**KIRKLEES METROPOLITAN COUNCIL
INVESTMENT & REGENERATION SERVICE**

DELEGATED DECISION TO DETERMINE PLANNING APPLICATIONS

Reference No:	2026/62/91307/E
Site Address:	46, Kingsley Crescent, Birkenshaw, BD11 2NL
Description:	Erection of two storey side extension with dormer
Recommending Officer:	Jennifer Booth

OFFICER REPORT

Proposed Elevations

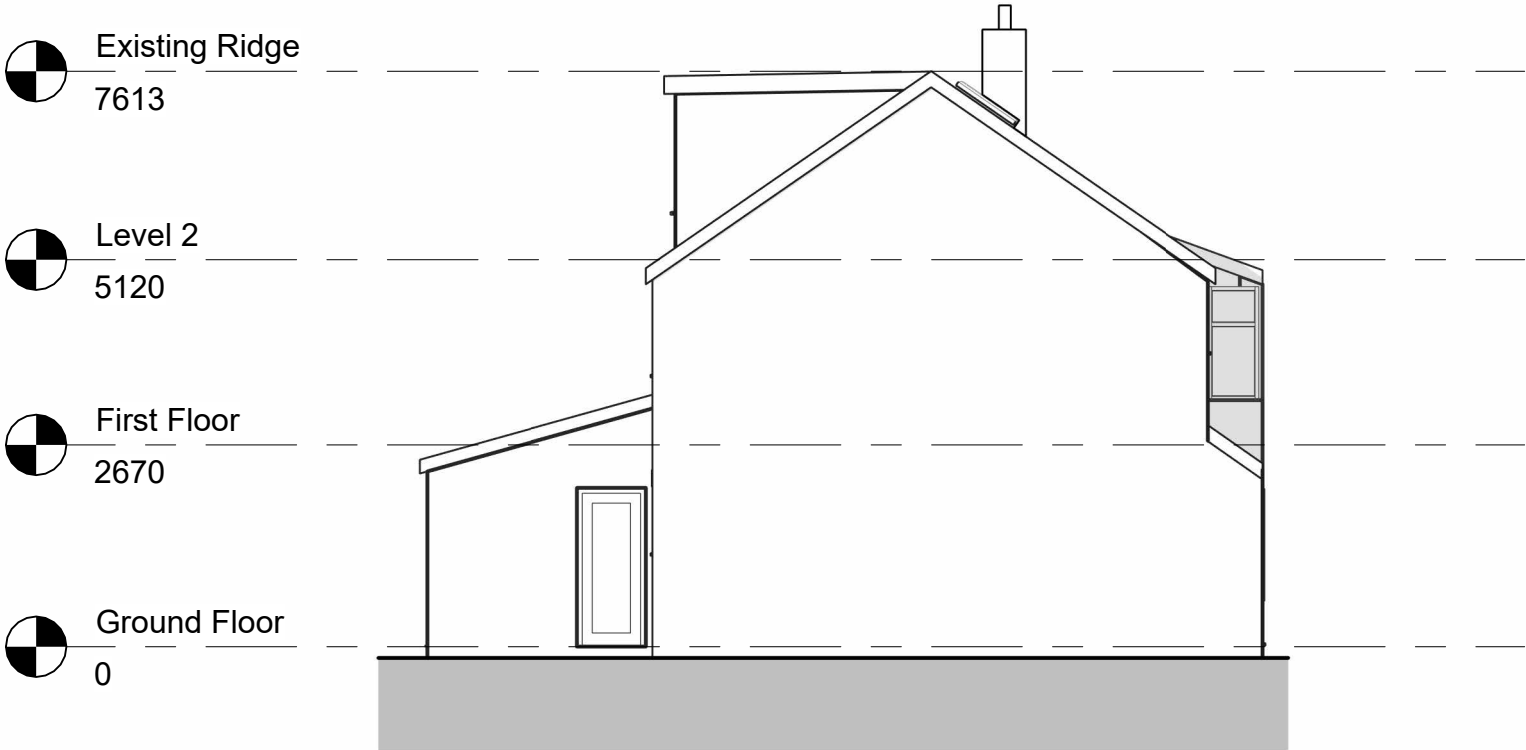
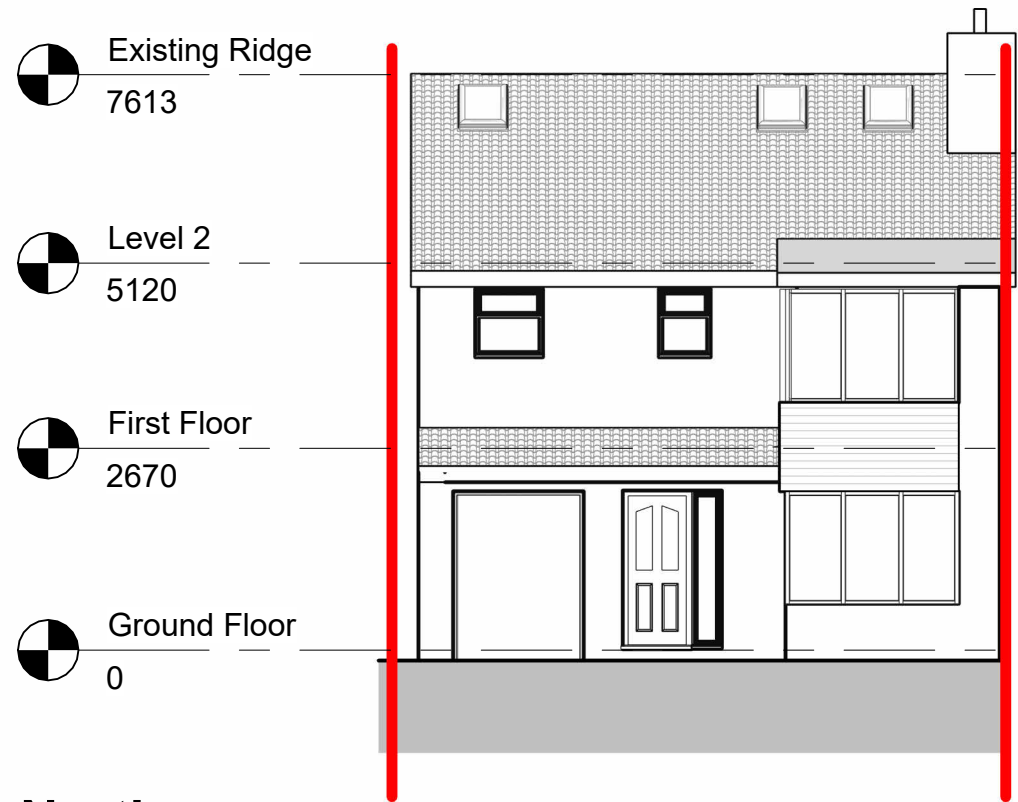
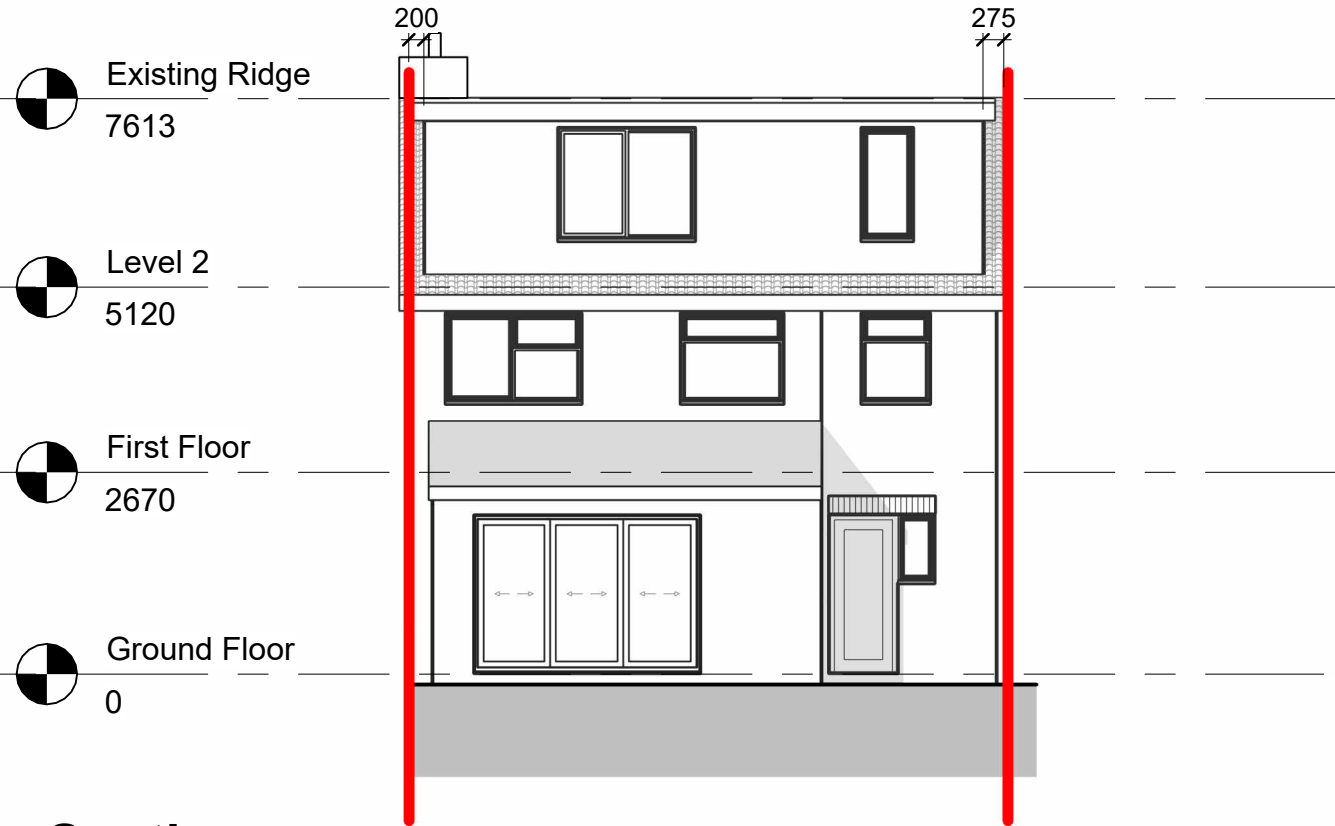
The side extension would lie flush with the front bay on the ground floor, including an area of porch and be set back in line with the main house at first floor. There would be no visible set back or set down, nor would there be a gap to the side boundary given the projection would be 2.3m. The roof form would be gabled.

The rear dormer would have width of 7.4m and a height of 2.3m.

The proposed two-storey side extension, by virtue of its scale, siting and design, would result in an unduly dominant addition to the host dwelling that fails to appear subservient. In particular, the absence of any set-back from the principal elevation or set-down from the main roof, coupled with the lack of a gap to the side boundary, would erode the visual separation typically expected between properties and harm the established sense of space within the streetscene. Whilst the use of matching materials is noted, this does not sufficiently mitigate the overall bulk and massing of the extension. Although there are examples of side extensions within the vicinity, these are generally characterised by subordinate design features, including set-backs and/or reduced ridge heights, and in many cases pre-date the adoption of the Council's SPD; as such, they are not directly comparable to the current proposal. Consequently, the development is considered to give rise to an unacceptable impact on visual amenity.

While it is acknowledged that a dormer positioned within the original roof slope has been deemed lawful under a Certificate of Lawfulness, the current proposal differs significantly in scale and form. The proposed dormer extends beyond the original roof, encompassing both the main roof and the roof of the proposed side extension. As a result, it appears overly dominant and lacks the necessary subservience to the host dwelling. Its increased bulk and footprint would create an incongruous addition that does not respect the proportions or character of the existing property.

Furthermore, the development would be readily visible from the open areas to the rear, leading to a harmful impact on visual amenity.

The proposed two-storey side extension, by virtue of its scale, siting and design, would appear unduly dominant and fail to be subservient to the host dwelling. The absence of a set-back, set-down and gap to the side boundary would erode the sense of space within the street scene, resulting in harm to the character and appearance of the area. To permit the proposals would be contrary to Policy LP24 of the Kirklees Local Plan, KDP1 & KDP2 of the House Extensions & Alterations SPD and Chapter 12 of the National Planning Policy Framework.

The proposed rear dormer, by virtue of its excessive scale, bulk and siting, extending across both the original roof and the roof of the proposed side extension, would appear as an overly dominant and incongruous addition that fails to remain subservient to the host dwelling. The development would result in a visually intrusive feature that is harmful to the character and appearance of the existing property and the surrounding area. Furthermore, due to its prominence and visibility from the open areas to the rear, the proposal would have an adverse impact on visual amenity. To permit the proposals would be contrary to Policy LP24 of the Kirklees Local Plan, KDP1 & KDP2 of the House Extensions & Alterations SPD and Chapter 12 of the National Planning Policy Framework.

Proposed Floor Plans

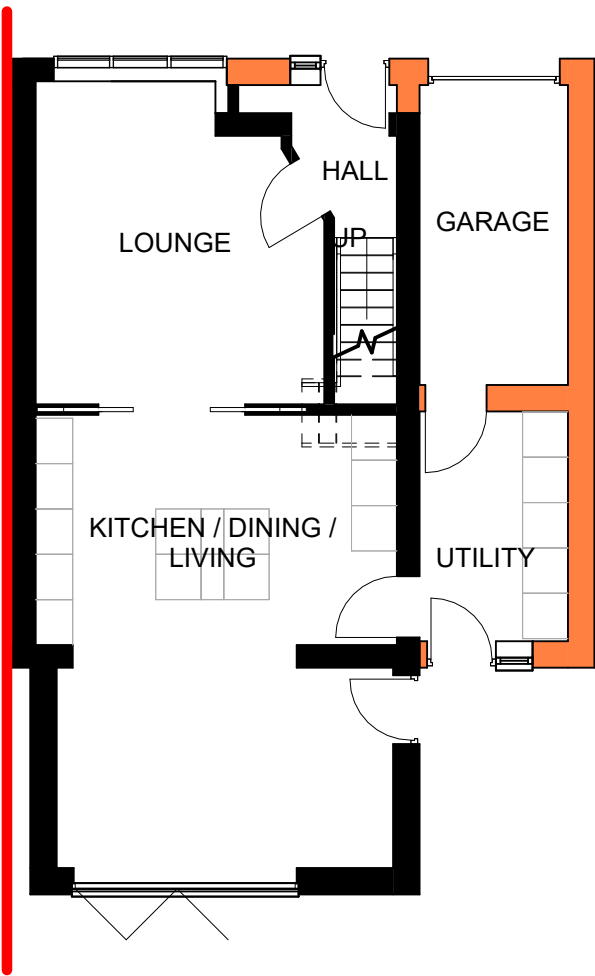
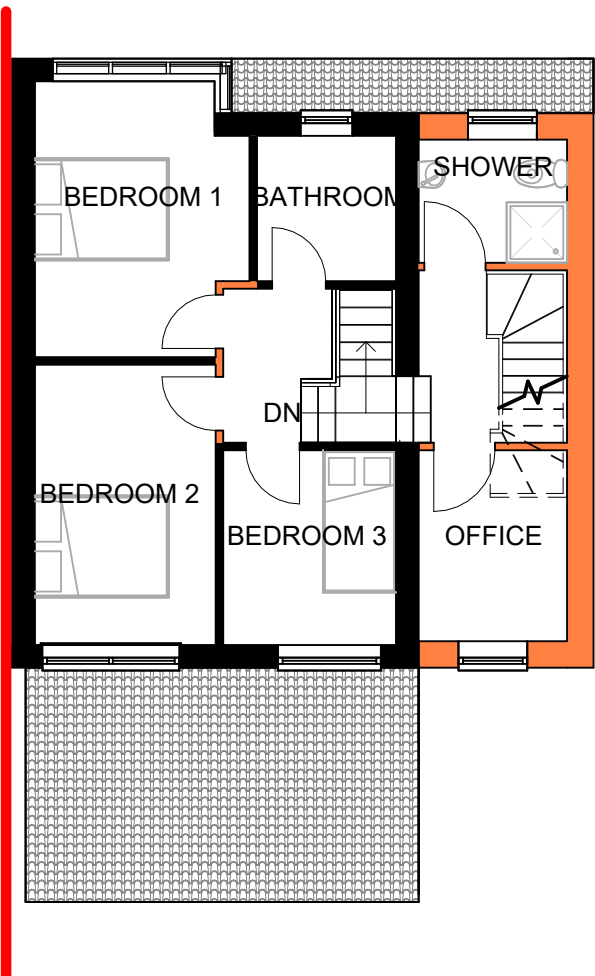
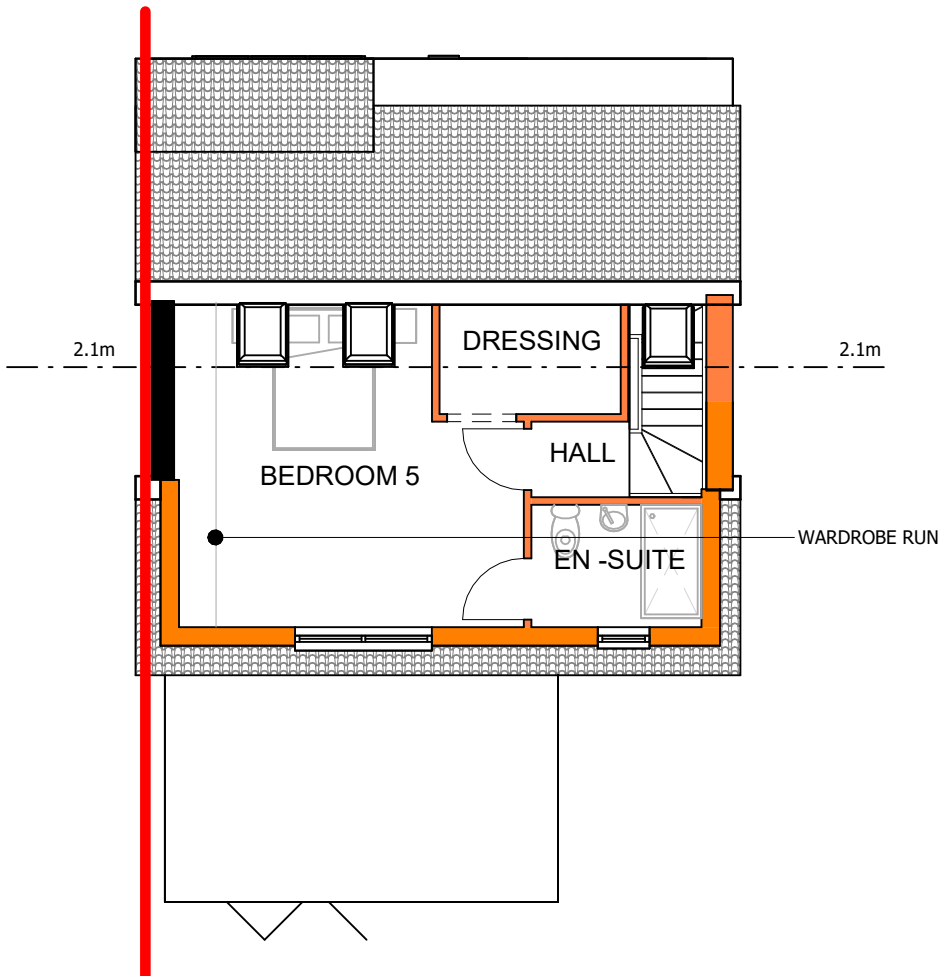
The side extension would reduce the space between the host property and the adjoining dwelling. However the neighbour's side elevation has limited openings and these appear to serve non habitable spaces. Furthermore, there would be no windows in the side elevation. Given this, there would be no overbearing, overshadowing or overlooking impact.
